January 11, 2024

**SUBJECT: WDFW COMMENTS ON CU-23-00006 HONEST CUT MEATS**

DATE: 10/30/2023
JOB: 2619.0001
BY: DDS
SCALE: 1" = 80'
FIGURE NO. 3 of 3

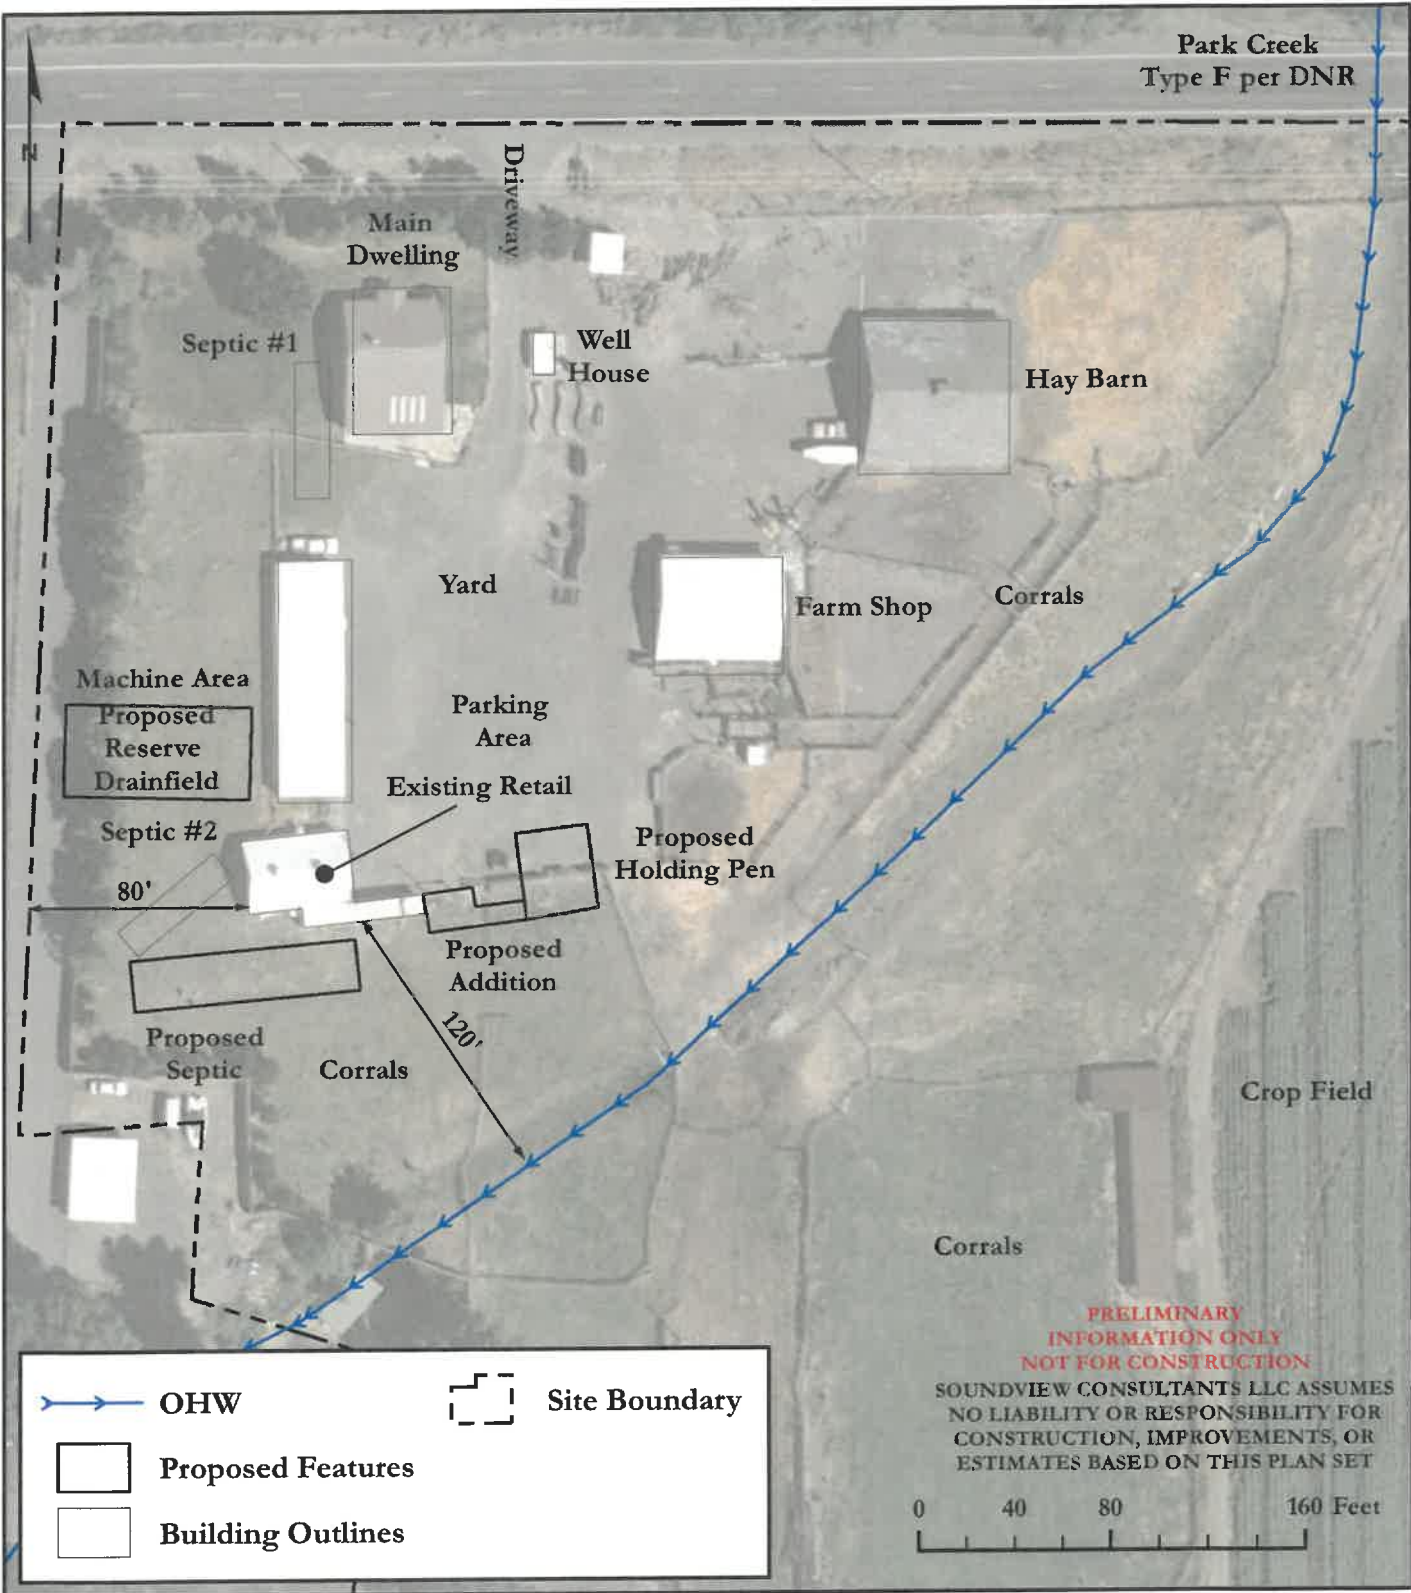
The use of prefabricated structures is likely to minimize the overall footprint and disturbance associated with the project, however there will be at least 480 square feet of new impervious surfaces near Parke Creek and a proposed holding pen that will likely send runoff toward Parke Creek. At least portions, if not all, of the development is within 100 feet from Parke Creek. The standard buffer width in the County's Critical Areas Ordinance would call for a 100-foot buffer plus a 15-foot setback. WDFW's guidance for riparian ecosystems in this location also recommends a 100-foot minimum setback to protect water quality. Ecology's [Voluntary Clean Water Guidance for Agriculture](#) recommends animal confinement areas (holding pens) be placed at least 150 feet away from streams in Eastern Washington and livestock exclusion of at least 100 feet to allow for a fully functioning riparian ecosystem.

The proposed prefabricated structures appear to be located near or within the 100-year floodplain as mapped by FEMA. Unmitigated placement of structures within the floodplain may result in

increased flood risks to existing structures and agricultural infrastructure. If compensatory flood mitigation is needed, WDFW recommends consideration of inset floodplain terraces adjacent to Parke Creek for effective flood mitigation and improved fish and wildlife habitat. We would be pleased to work with the applicants to further explore this option.

There may be some gray area as to the applicability of the VSP to this proposal, but WDFW strongly encourages the applicants to include native woody riparian vegetation along Parke Creek to mitigate impacts from placing and operating these new facilities in close proximity to Parke Creek. Enhancing the riparian vegetation through this reach would help ensure the project does not degrade the water quality or Fish and Wildlife Habitat Conservation Areas on the property and would be consistent with [Kittitas County's VSP Approved Work Plan](#). Establishing native woody vegetation along Parke Creek in this location may also help control the invasive reed canary grass that dominates the riparian area on this property.

WDFW recommends a robust riparian establishment project be incorporated into the project proposal such that the project will be consistent with the goals for the local VSP work group. We welcome the opportunity to collaborate with the applicants and County to ensure this project will protect and enhance critical areas while also maintaining agricultural viability in Kittitas County.
